6 August 2022

National Trust objection relating to the Powerhouse Ultimo Renewal - State Significant Development (SSD-32927319)

Project No.	2138	Scale @ A2	1 : 500
	Date	SEPT 2022	Co-Ord	
	Dwnn	CT	Chck	MB
Drawing Status		FOR APPROVAL		
Drawing No.			Revision	
AR 0500			10

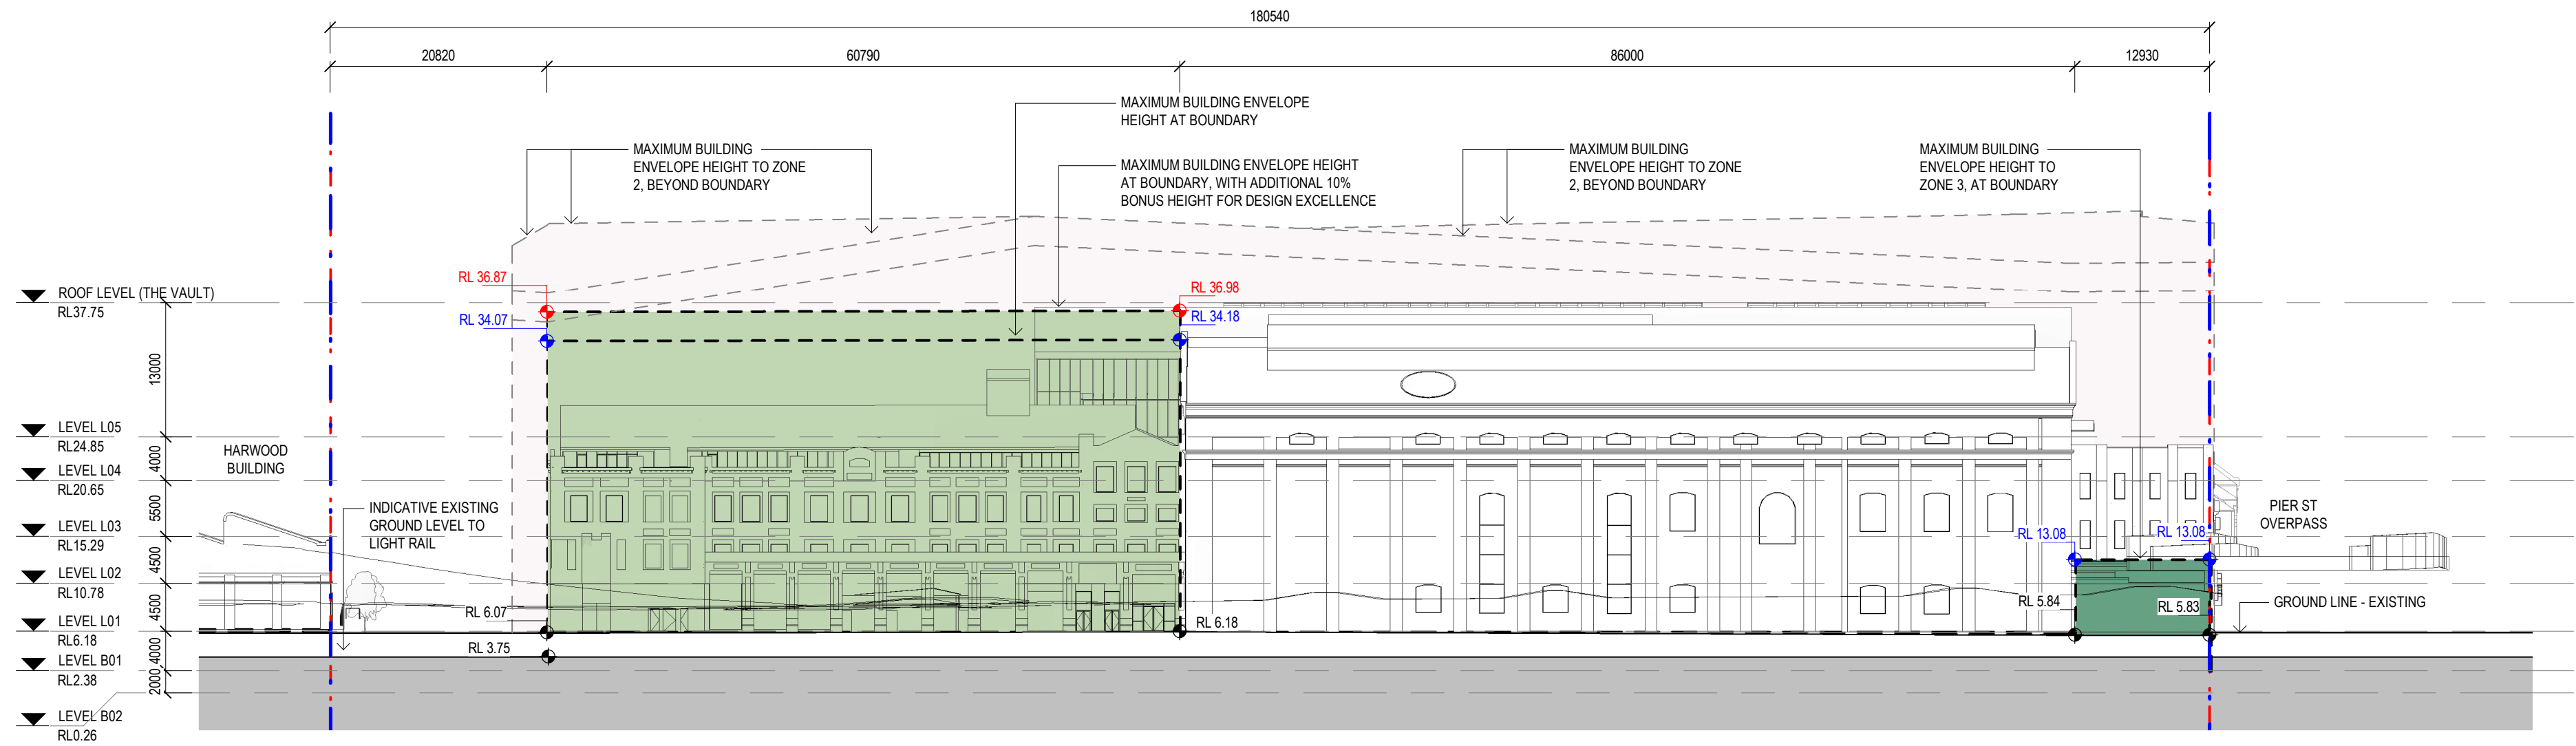
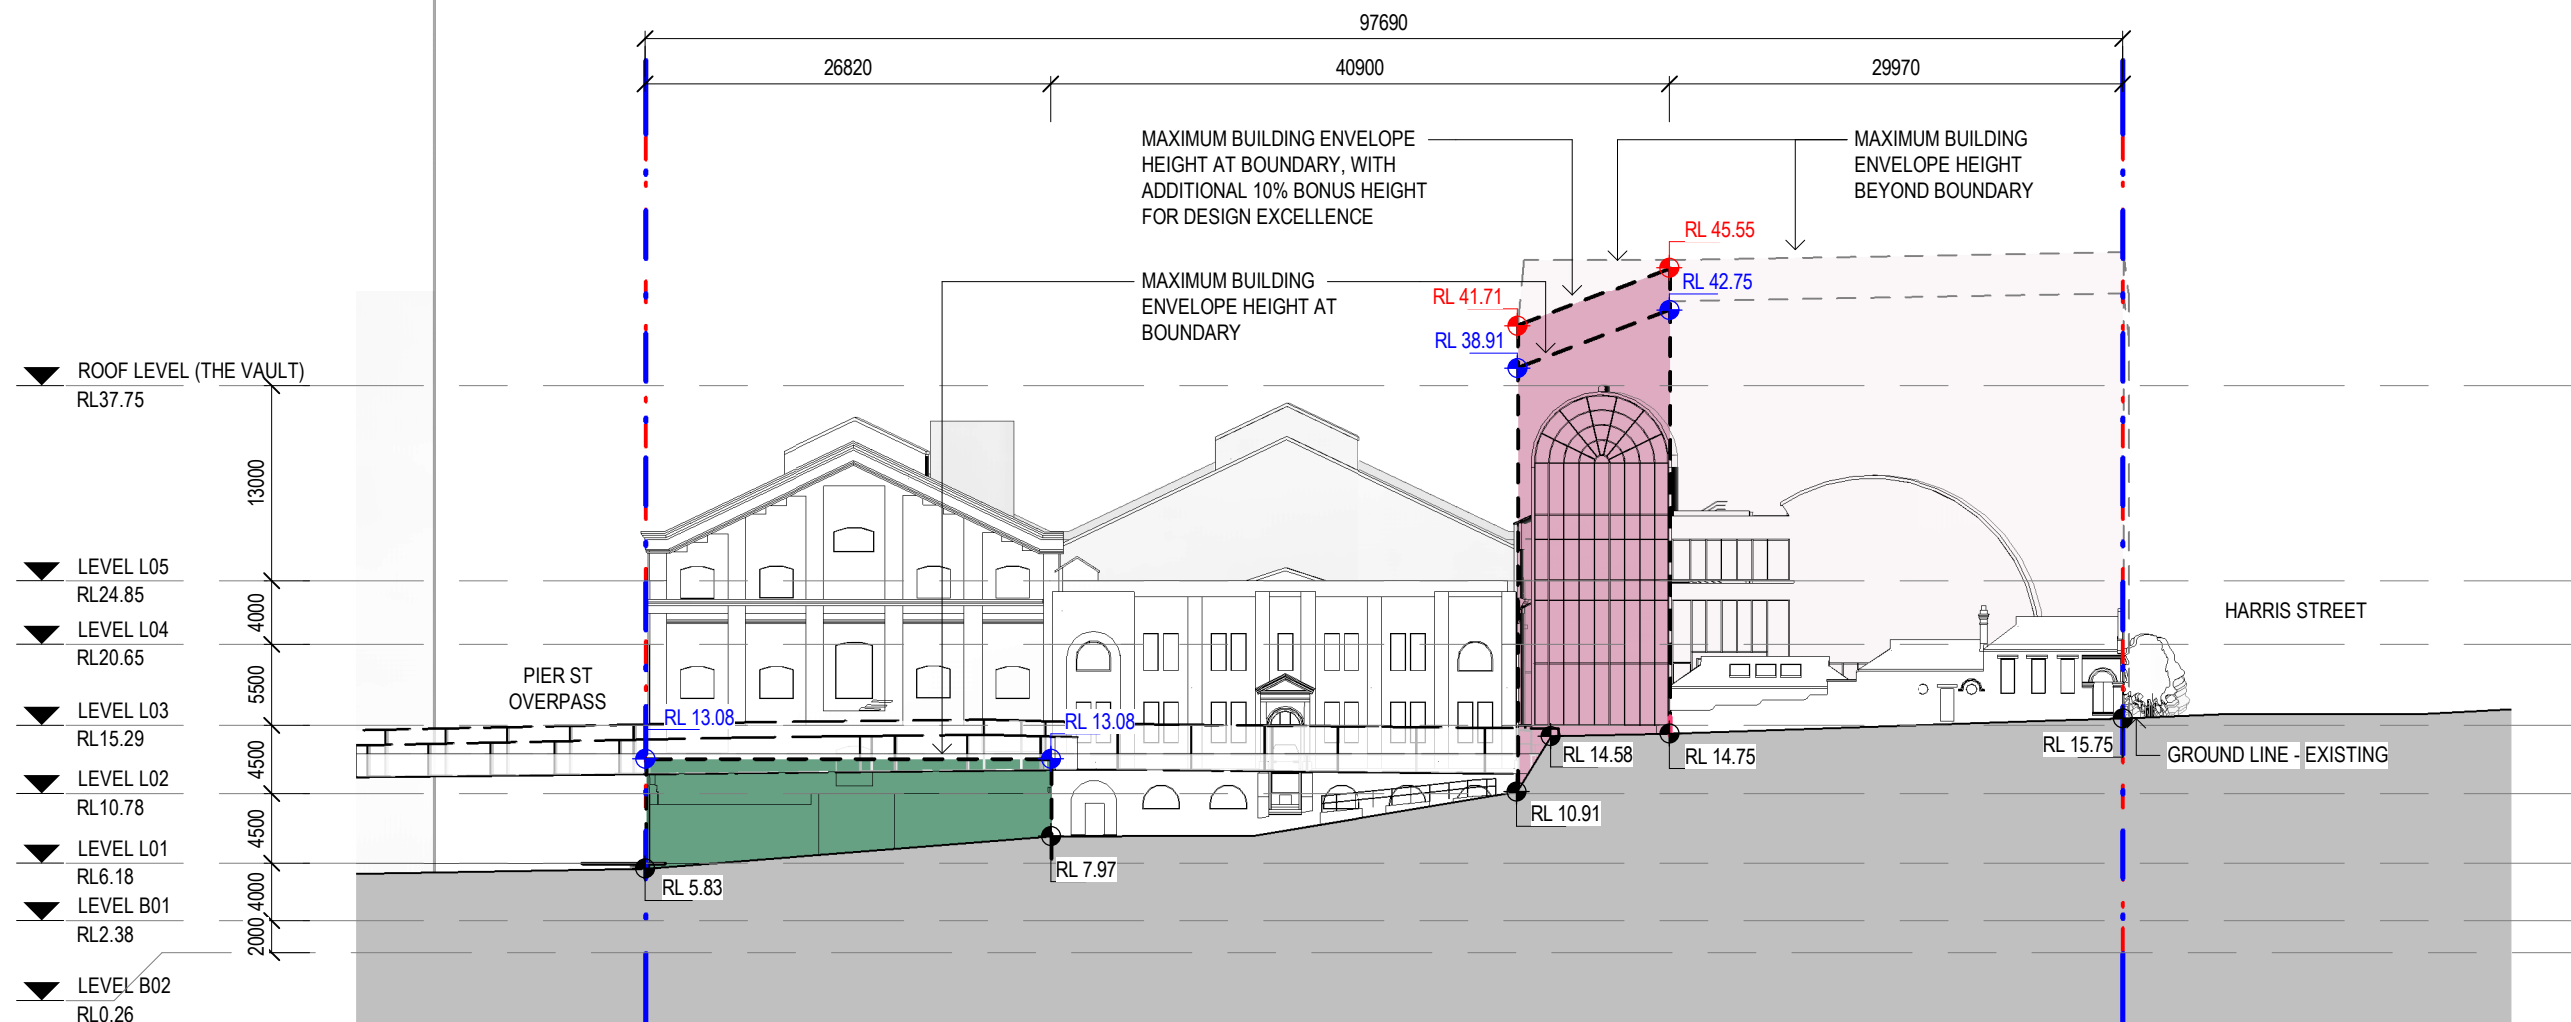
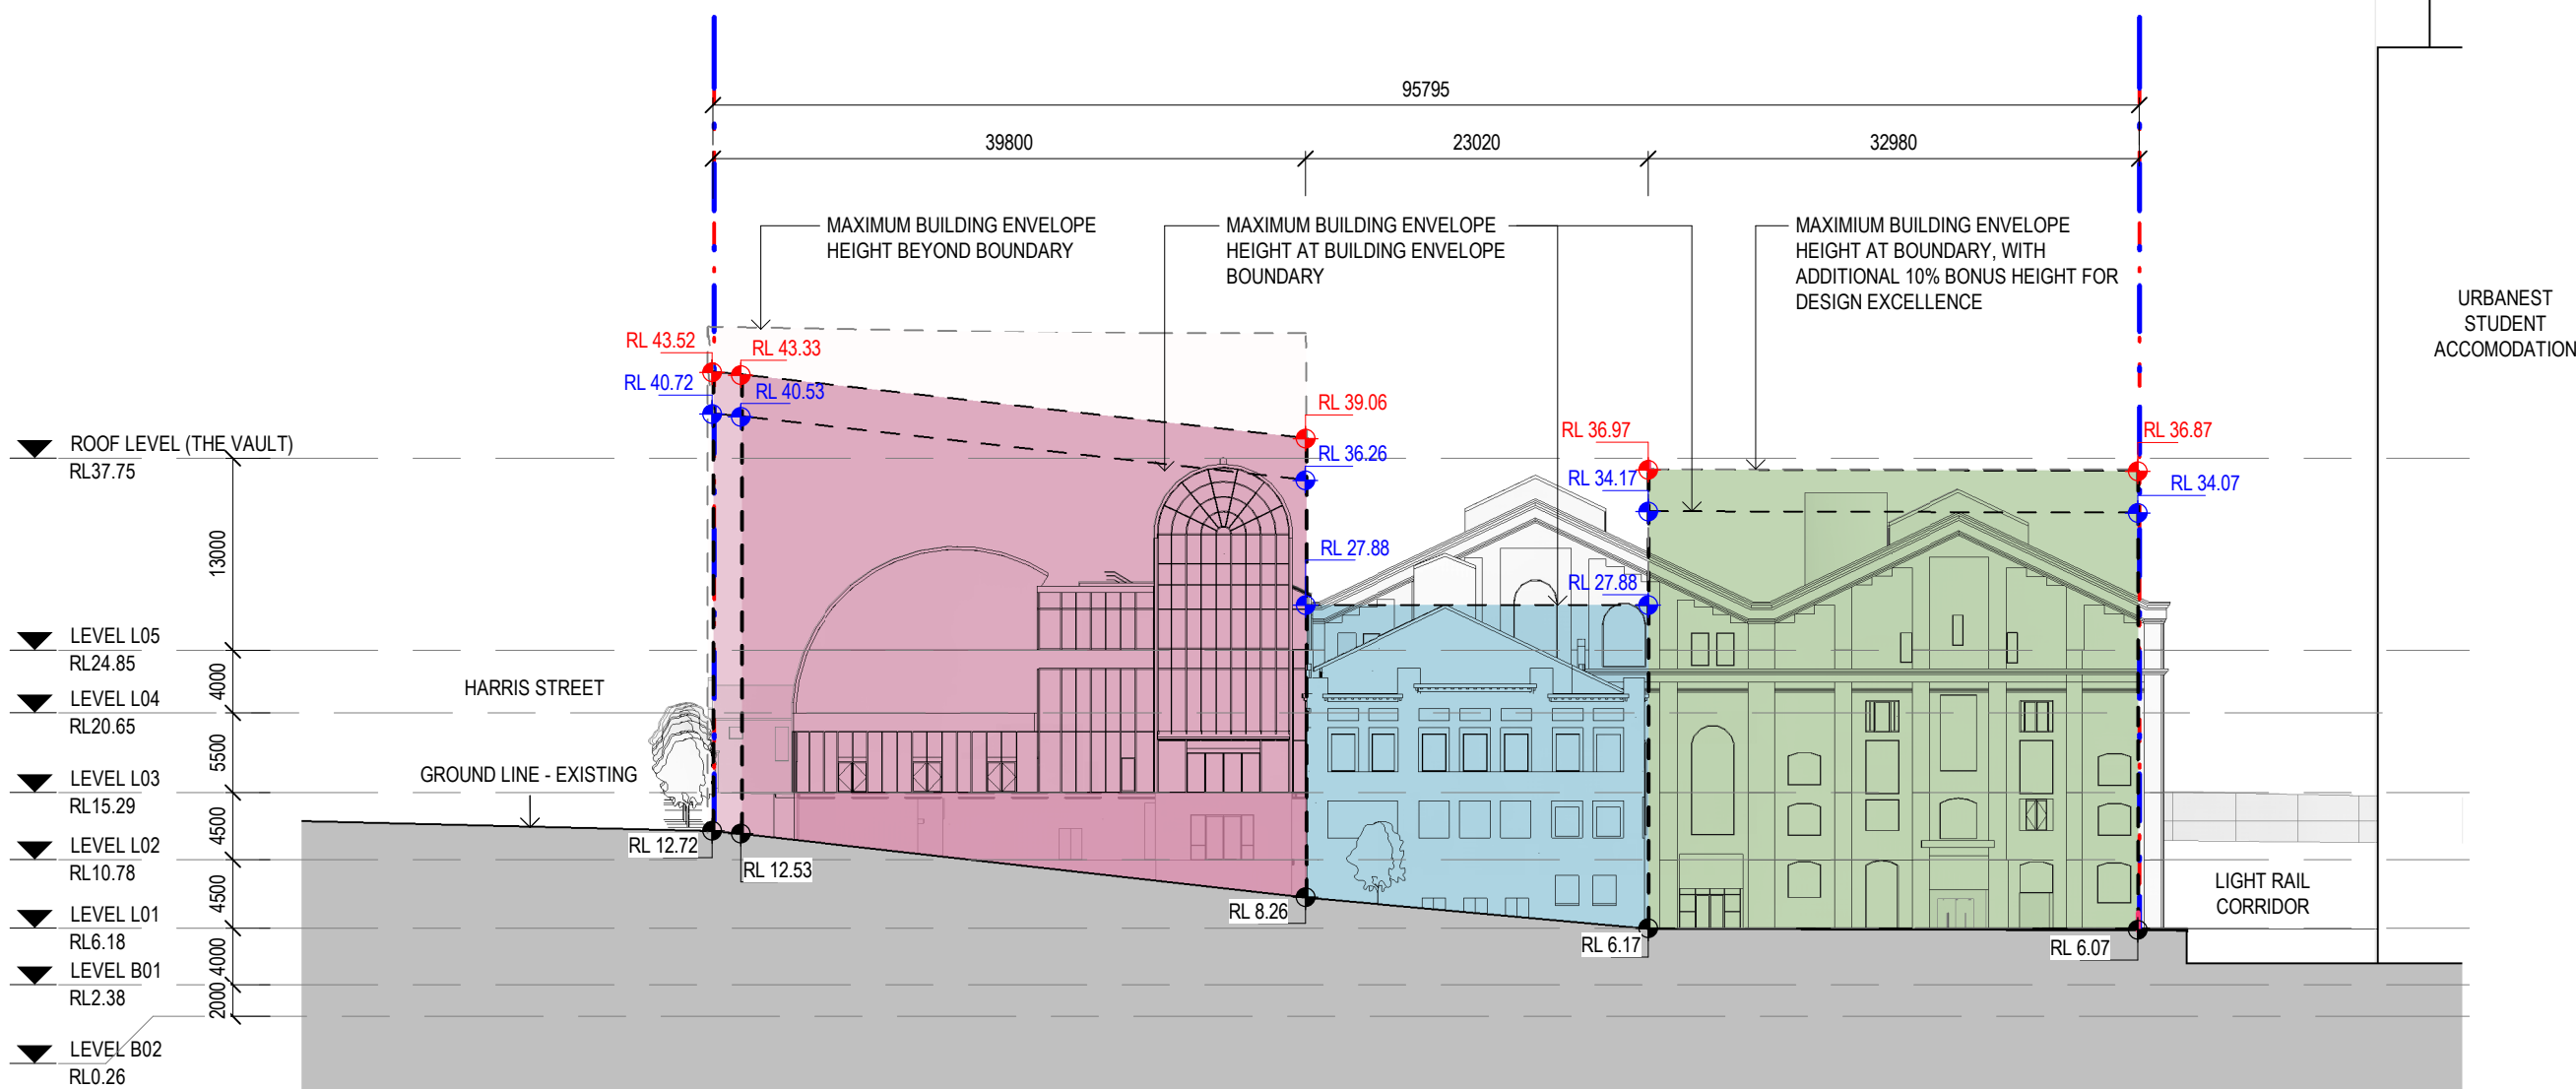
The Trust does not support the maximum building envelopes proposed in the application. An adequate assessment of the impact of proposed built form and urban design cannot be made based on the shaded ‘boxes’ placed over heritage buildings as currently exhibited.

It is unclear and unjustified as to why a “maximum building envelope” approach has been used. The exhibited documents clearly state that due significant heritage buildings, a maximum building envelope **would not be achievable** across the entire site. The question must then be asked why consent is sought for a blanket maximum building height envelope across the entire site?

The impact of the proposed additional built form above the heritage items is not adequately assessed or acknowledged. Such additional works would obscure the distinctive profiles and forms of heritage listed buildings of exceptional significance and deeply affect the legibility of their historic built forms and significant views.

The maximum building envelopes are not supported in any way. These should be immediately revised to create envelopes that are appropriate to the heritage structures and the wider site. The design brief should not include any additions at all above the original state-listed Power House components of the site.
